**KIRKLEES METROPOLITAN COUNCIL
INVESTMENT & REGENERATION SERVICE**

DELEGATED DECISION TO DETERMINE PLANNING APPLICATIONS

Reference No: 2020/62/90016/W
Site Address: 29, Warwick Avenue, Golcar, Huddersfield, HD7 4BX
Description: Erection of attached garage
Recommending Officer: Laura Yeadon

DECISION – Conditional Full Permission

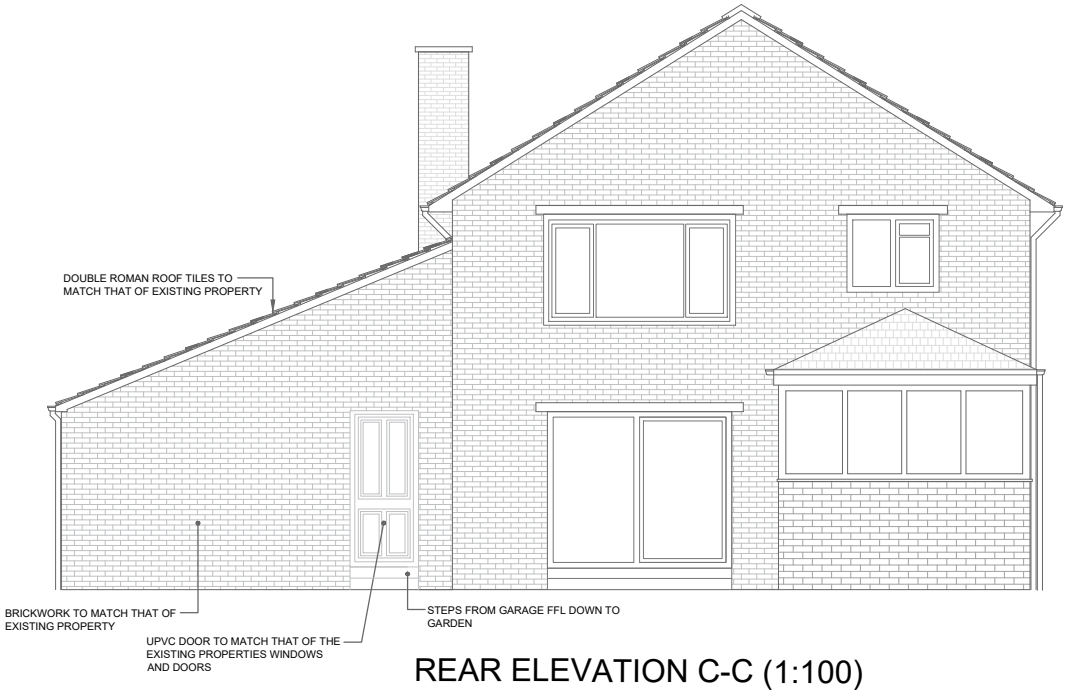
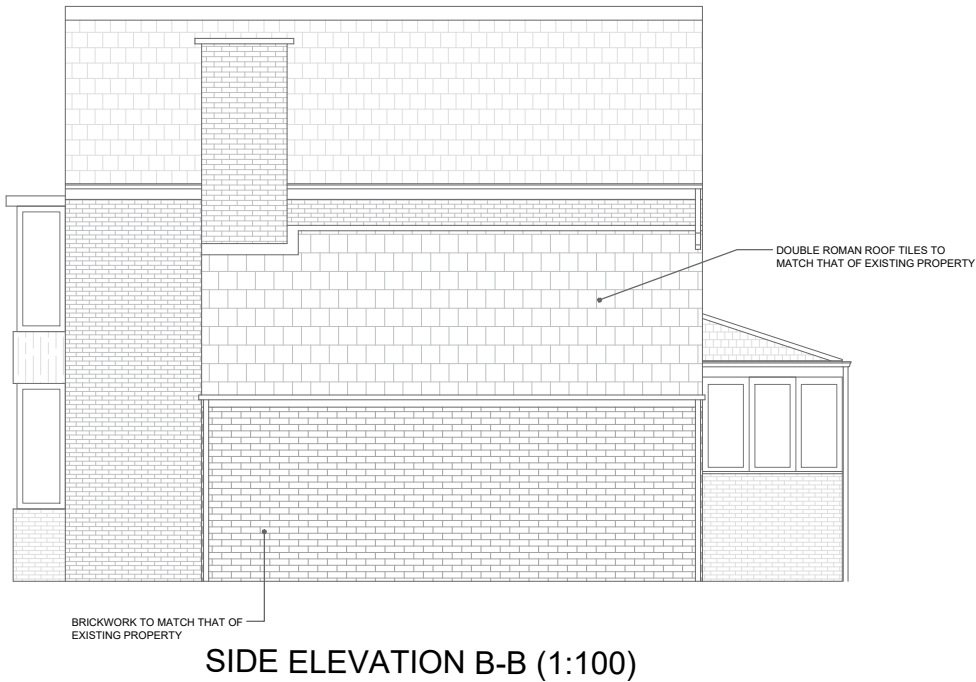
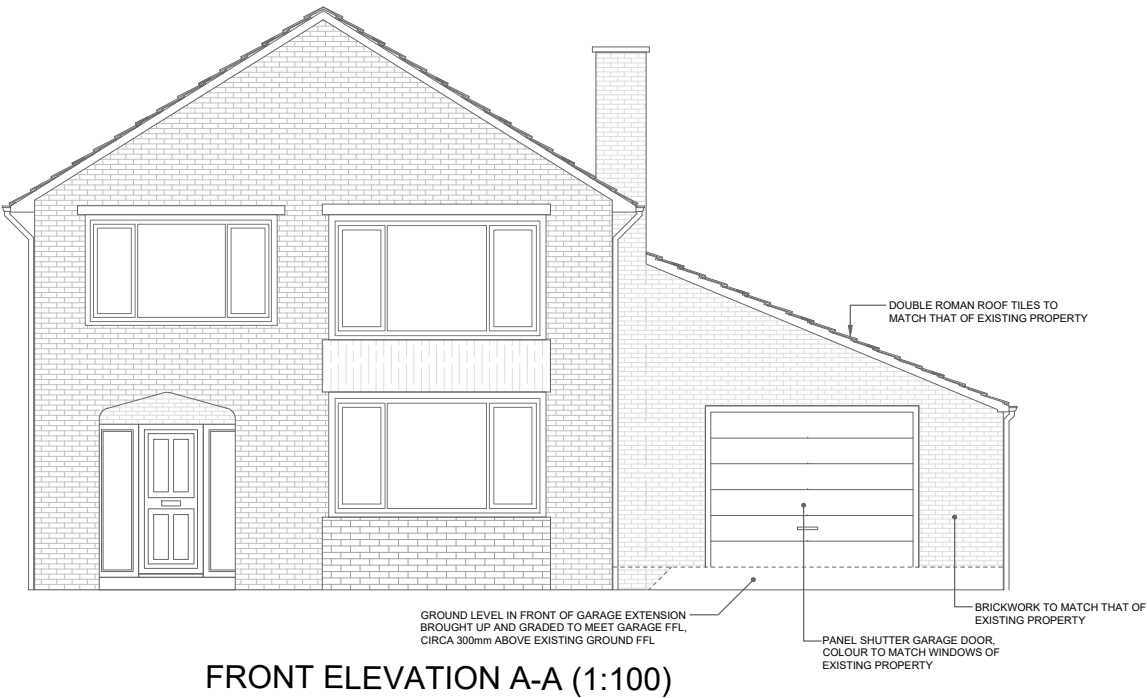
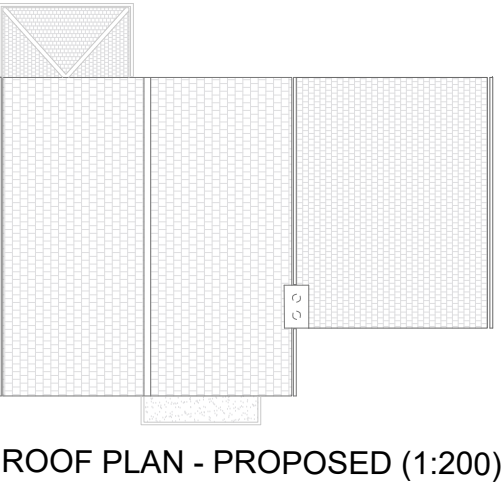
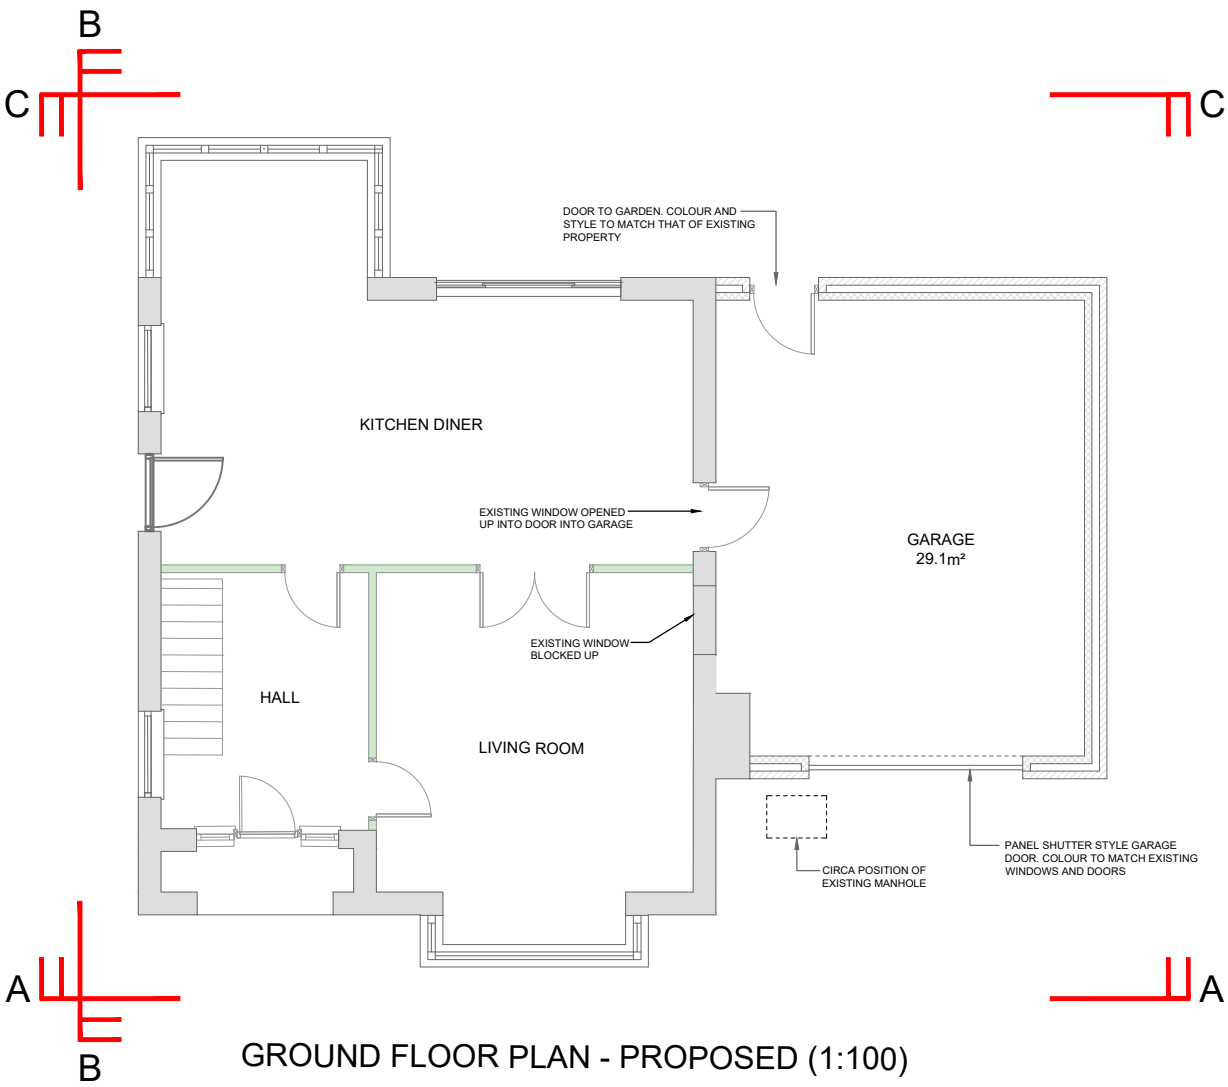
The extension would be set back from the front elevation of the property by 2 metres lying flush with the rear elevation and would be single storey in height with a long sloping mono-pitch roof ridge that would be set below the existing eaves. The scale of development would clearly appear as an addition to the property and not part of the original dwellinghouse.

The fenestration details include a garage door to the front elevation and personnel door to the rear elevation which would be finished in a colour to match the existing. There are no proposed openings facing the adjacent bungalow, 38A Arthur Street which is screened from the application site by beech hedging, some of which would be removed to accommodate the garage, and is set on a higher ground level due to the topography of the area.

In terms of overlooking, the plans indicate that there would be new openings within the front and rear of the garage which would not cause a loss of privacy. There are no proposed openings within the side elevation of the extension however due to the close proximity with the shared boundary, it is considered reasonable to remove permitted development rights for windows to be positioned in this elevation, including in the roof, to prevent overlooking at close proximity.

With regard to overshadowing and/or being overbearing, the dwelling is detached and separated from the adjacent property, No. 38A which has a rear elevation facing the side elevation of the application property. There is a small window located within this elevation and it is noted that some screening would need to be removed to accommodate the proposal. Given the difference in levels and the orientation of the extension in relation to the neighbour it is not considered that the extension would cause significant harm to this opening by being overbearing or from overshadowing.

Permitted Development) (England) Order 2015 (or any order revoking or re-enacting that Act or Order with or without modification) no new door or window openings other than those expressly authorised by this permission shall be constructed in the side elevation external walls or roof of the extension hereby approved at any time without the prior written approval of the local planning authority.

Dwg Title: PLAN SHOWING TREES & PROPOSED

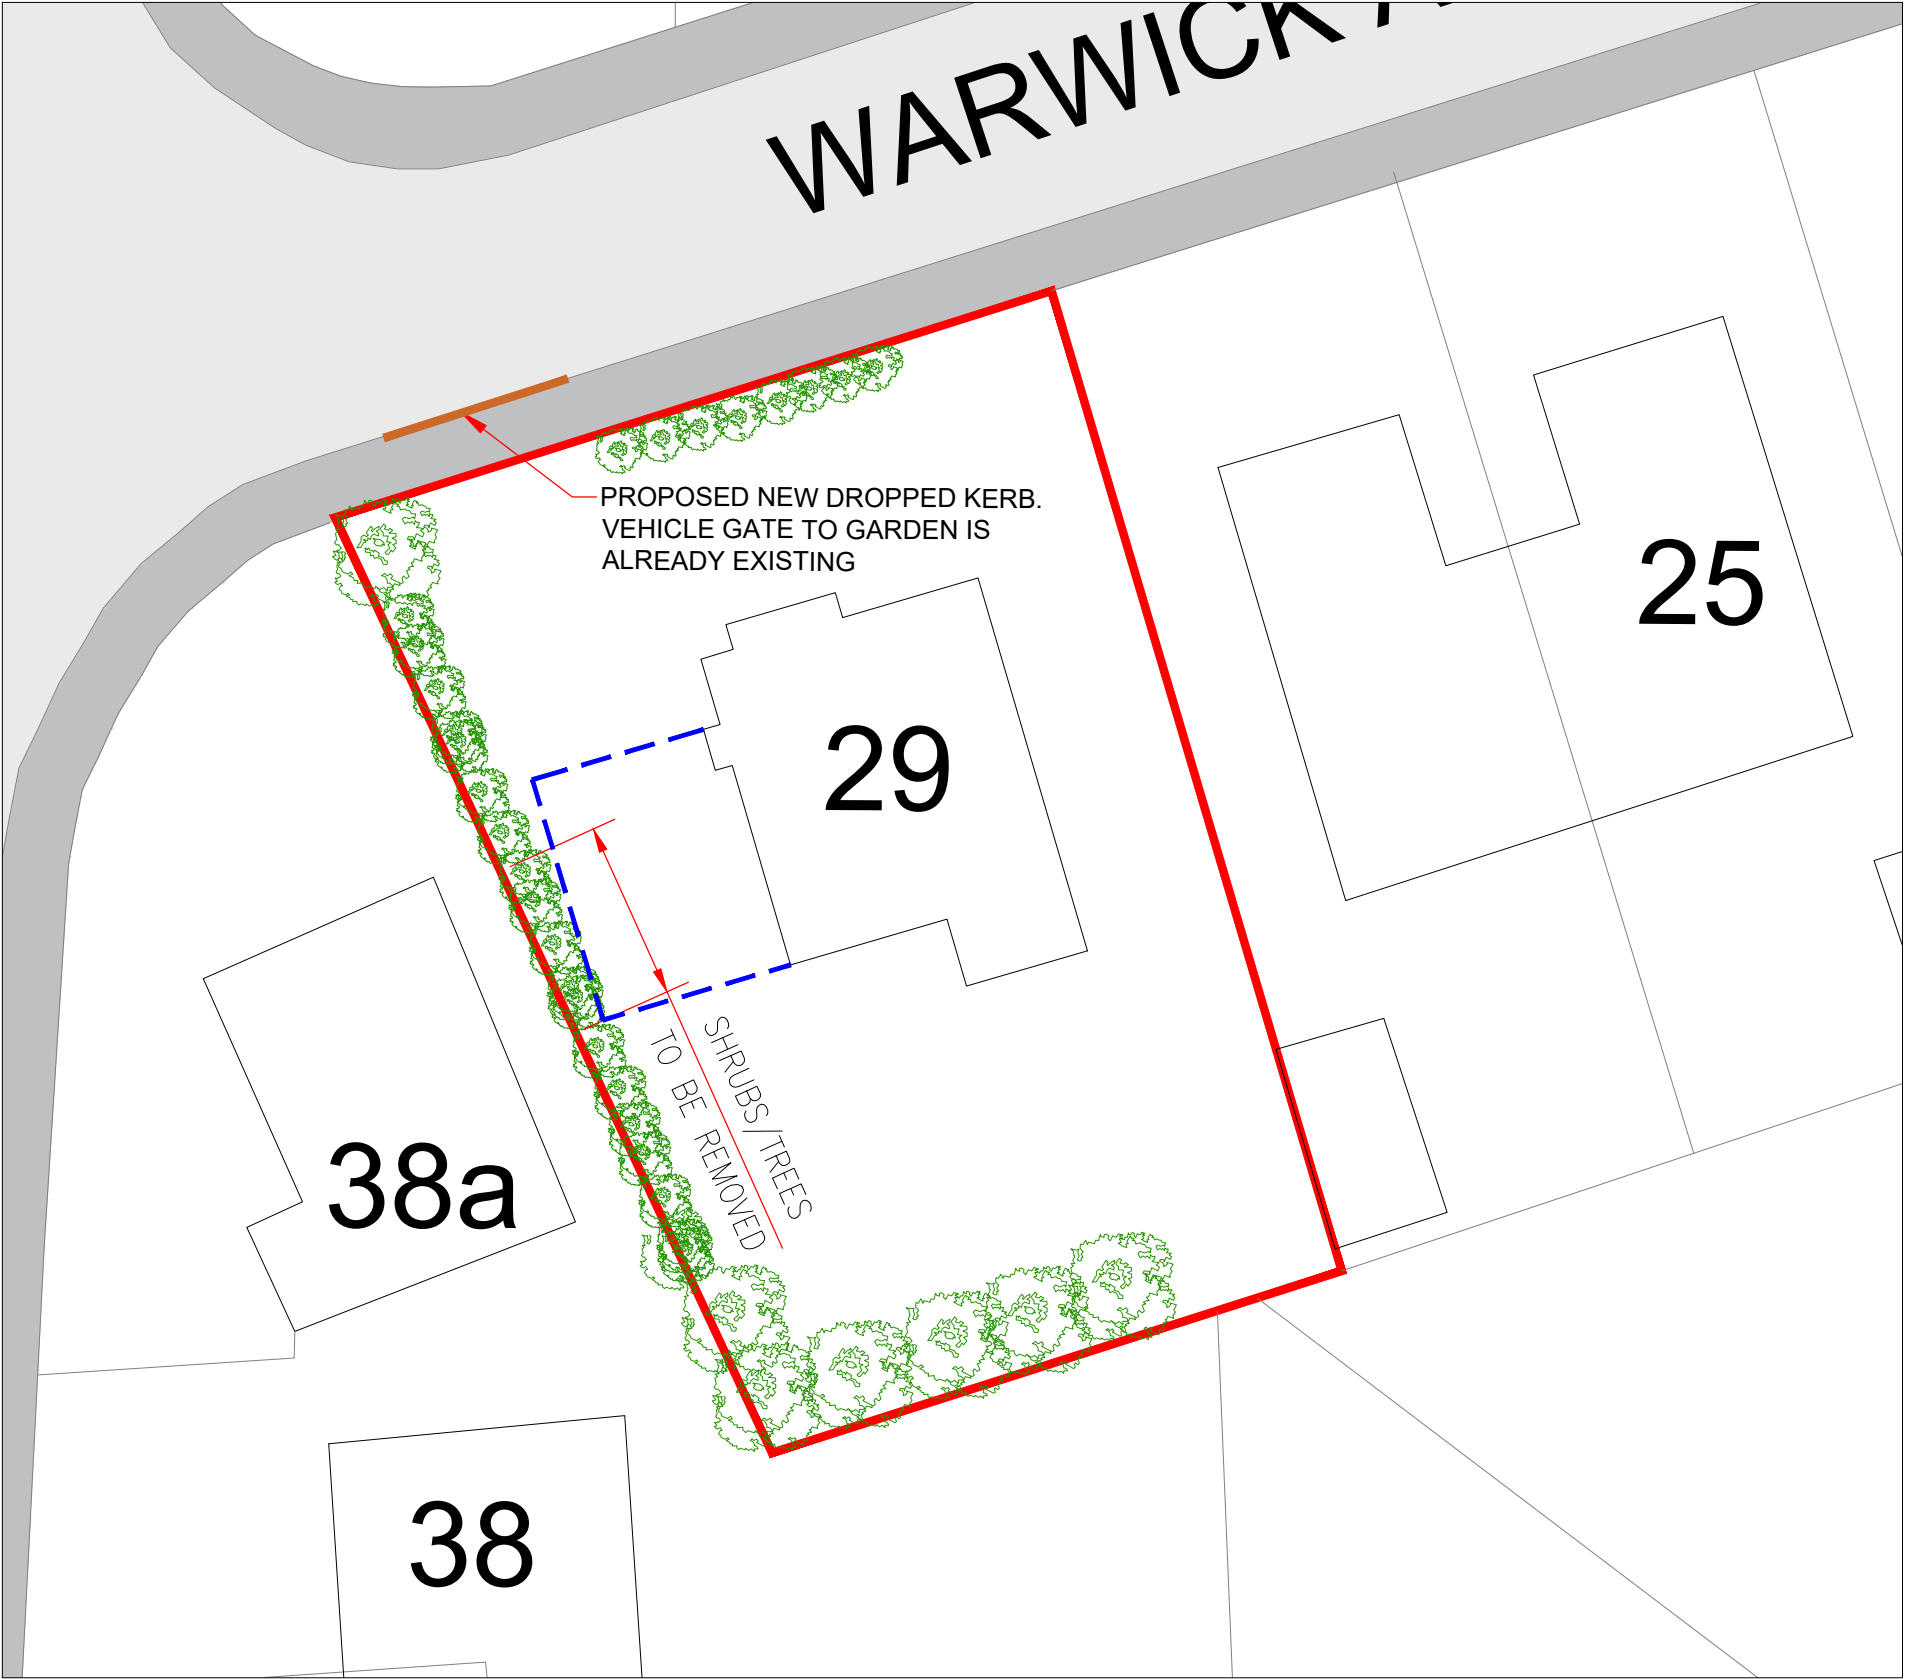
The proposal would provide garage accommodation for the dwelling and is of a sufficient size to accommodate 1 no. vehicle with additional accommodation due to its width. There is a driveway running to the other side of the property which can accommodate further vehicles. To access and facilitate the new garage, a new dropped crossing would be required. This would require consent from the Highway Authority and details shall be added to the decision notice as to the contact details for an application to be made.
